Bramford to Twinstead Reinforcement

Document 8.7.2: Draft Statement of Common Ground Historic England

Final Issue A

December 2023

DEDHAM VALE EAST SEALING END COMPOUND:
 PLAN VIEW
 SCALE 1:200

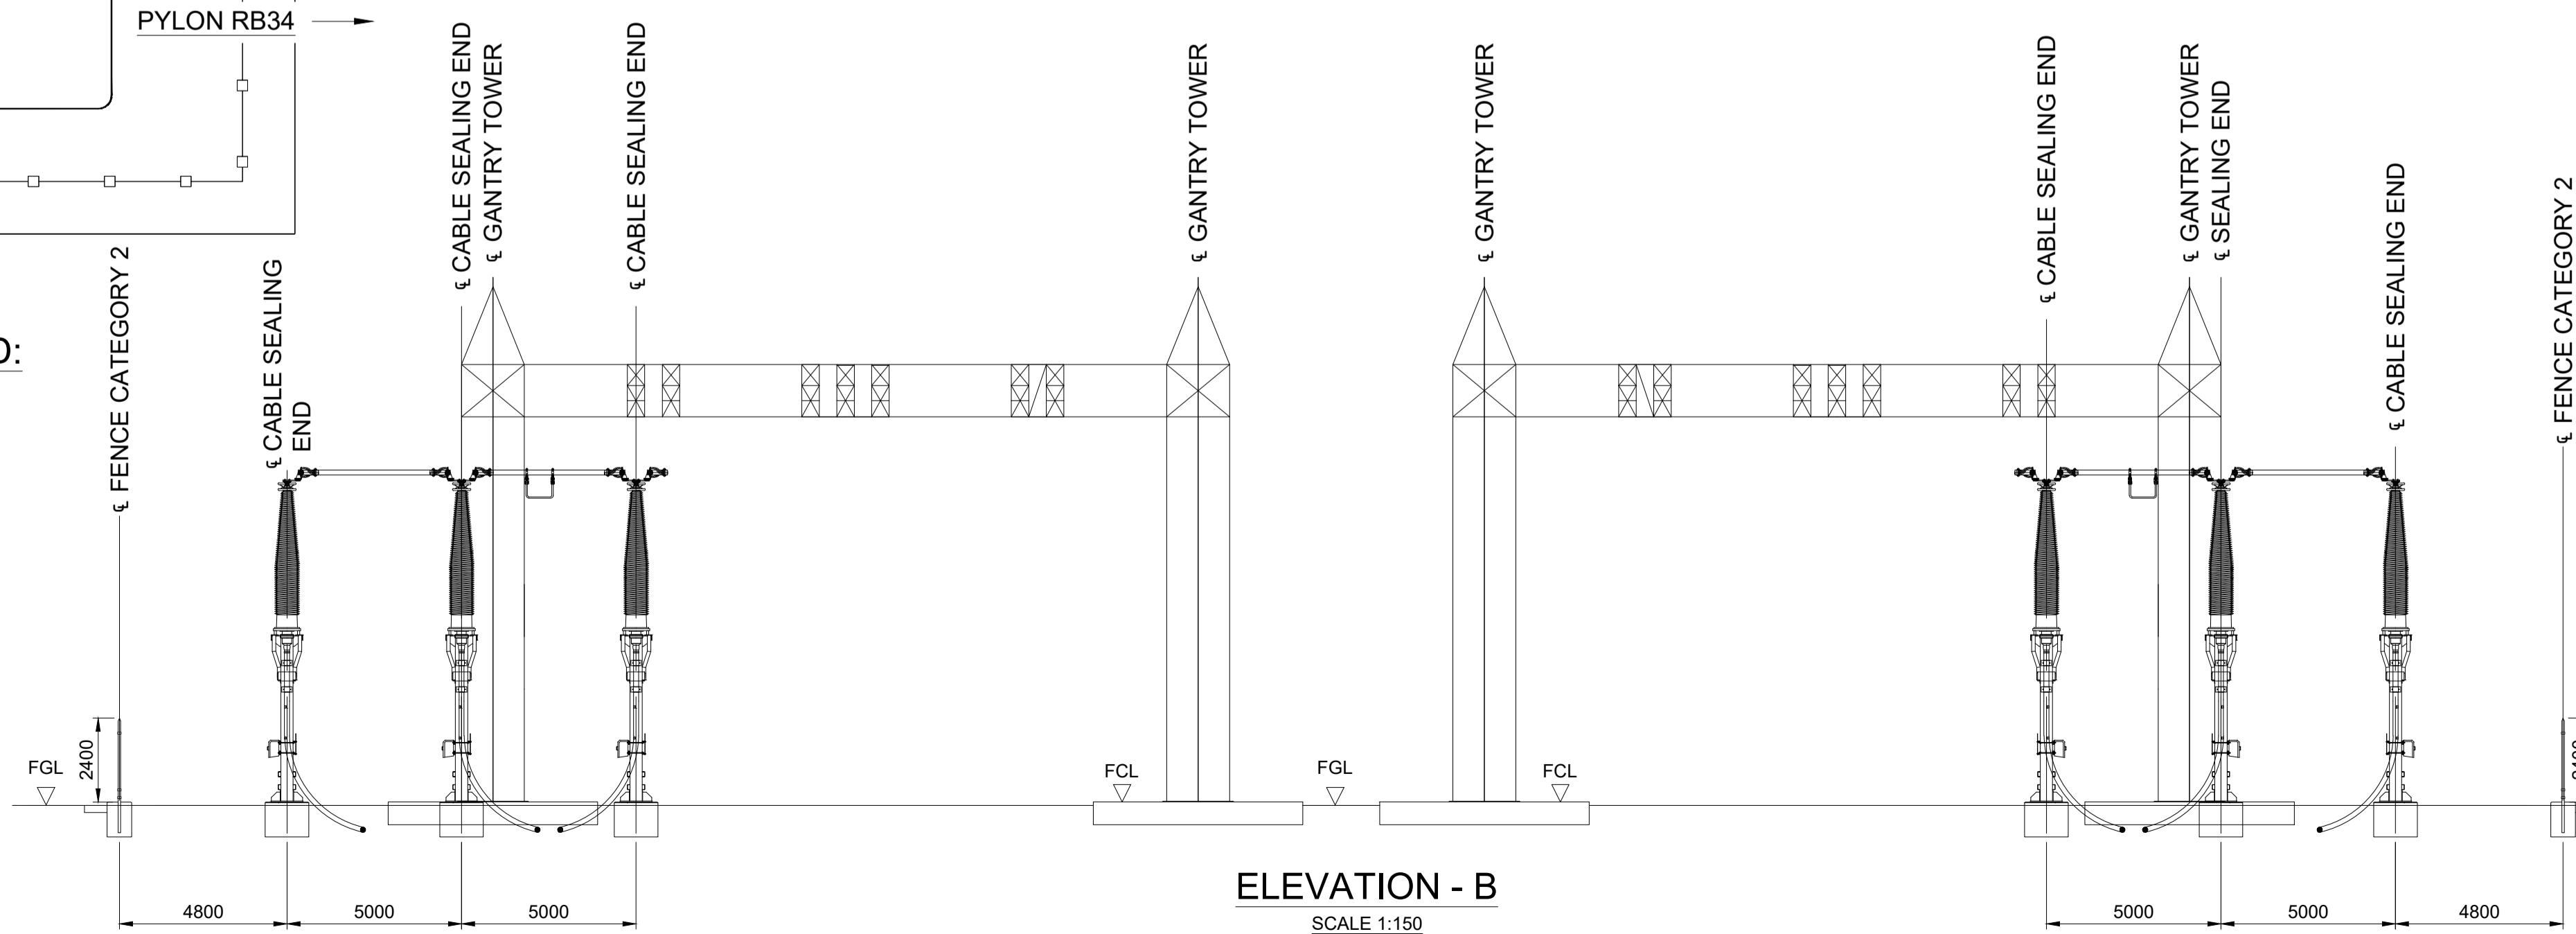
1.4	Location of Dedham Vale East cable sealing end (CSE) compound	That the Dedham Vale East CSE compound was relocated to its current position (as presented in the application for development consent) in response to feedback from Historic England to move the CSE compound further away from the Polstead Conservation Area.	Agreed	Agreed	Agreed
2 Assessment Approach and Methodology
